15237
22 March 2017

**RESPONSE TO DEPARTMENT QUERIES
NORTH PLOT AND SQUARE (SSD 7021)**

This letter, prepared by JBA on behalf of the proponent, sets out the responses to the queries raised in the Department of Planning and Environments (the Department) correspondence dated 3 March 2017.

TITLE  
FLOOR PLAN LEVEL 01  
DWG NO.  
ADP03

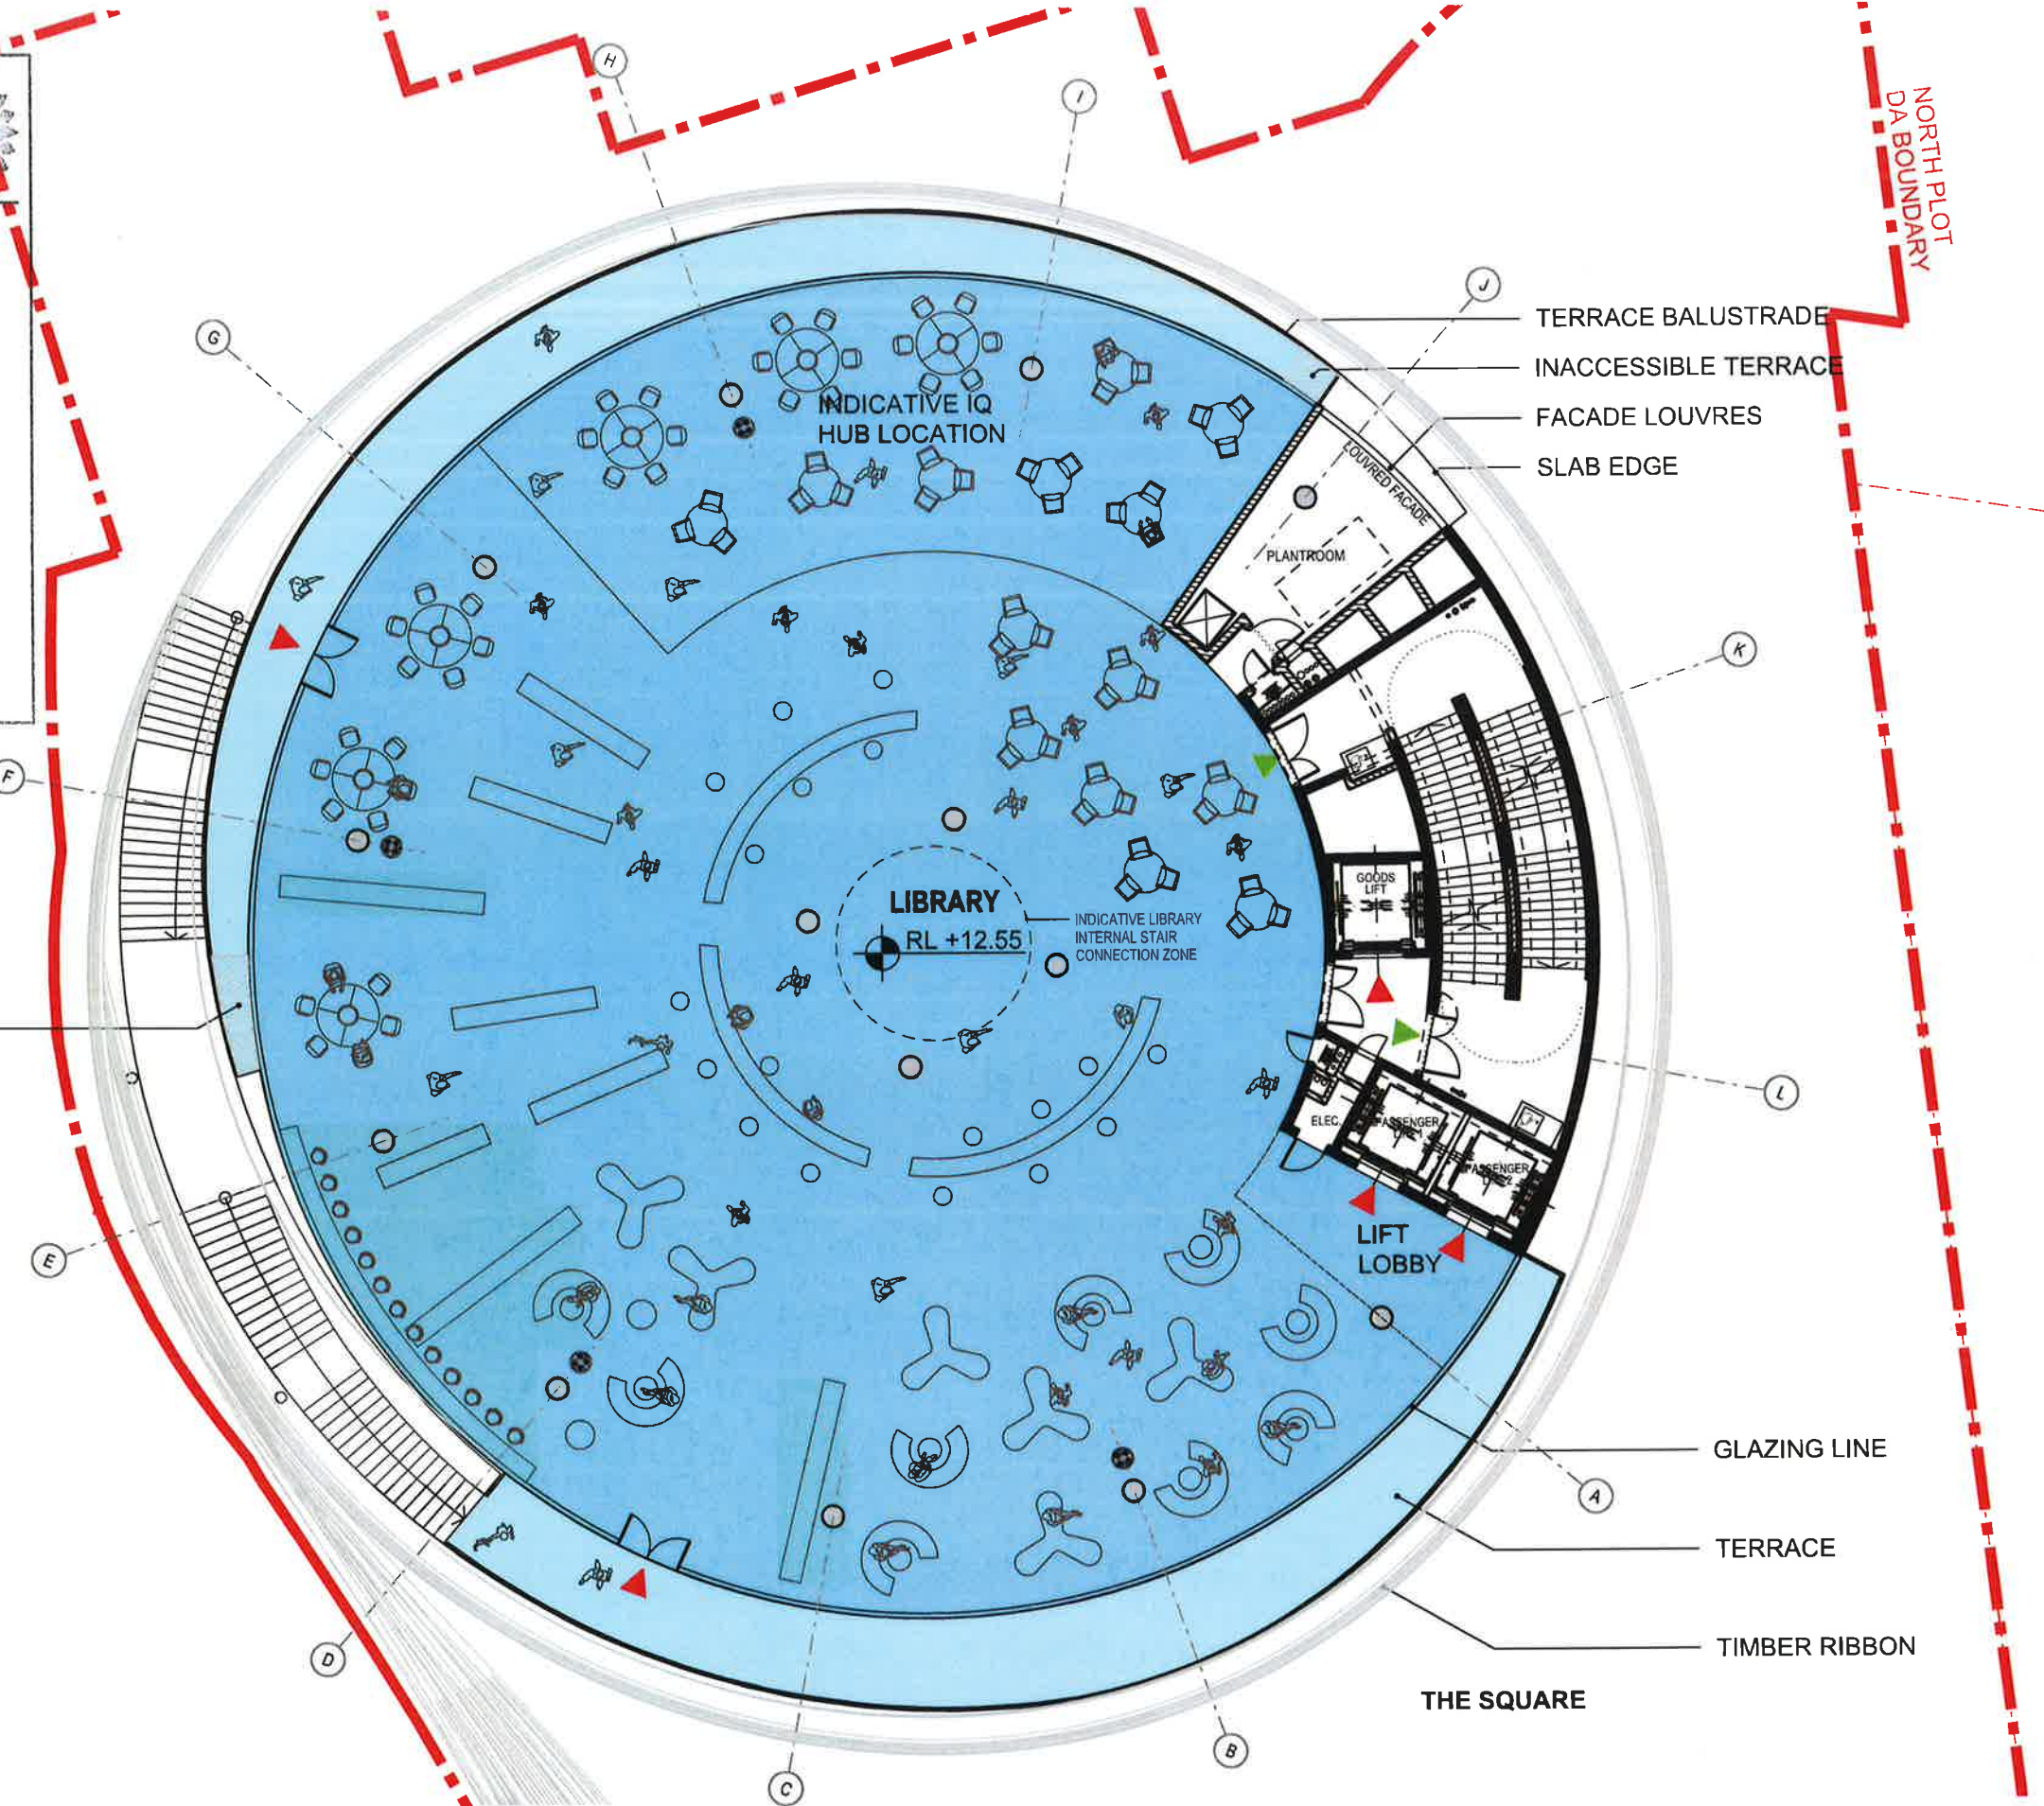
The Department has requested the following be provided in regard to the stair encroachment into the Boulevard:

- options for increasing the permeability/transparency of the step risers to increase views through the structure; and
- further justification in response to sub-point (d) of condition B4A.

- The stair risers have a transparency of 39%, with the perforated pattern containing 8mm circular openings every 8mm. This provides an open and visually permeable outcome, with varying degrees of openness as pedestrians travel through the Boulevard.

- The level of visual permeability of the stair riser is maximised in the context of DDA requirements for users with a visual impairment. The stair is visually permeable when pedestrians travel down the Boulevard, but is more opaque for users ascending the stair.

- The stair is currently designed to structurally contain only two thin lightweight columns, meaning there are limited vertical obstructions introduced into the Boulevard, in turn increasing the visual permeability of the structure. Any further reduction in the structural support of the stair stringers would require additional columns within the Boulevard, resulting in a potentially heavier and more obstructed encroachment.

- The encroachment of the stair into the Boulevard is minimal with only a small portion of the stair entering the Boulevard setback and therefore the Boulevard is largely retained as a visually unencumbered space (refer to views in **Figure 2**).
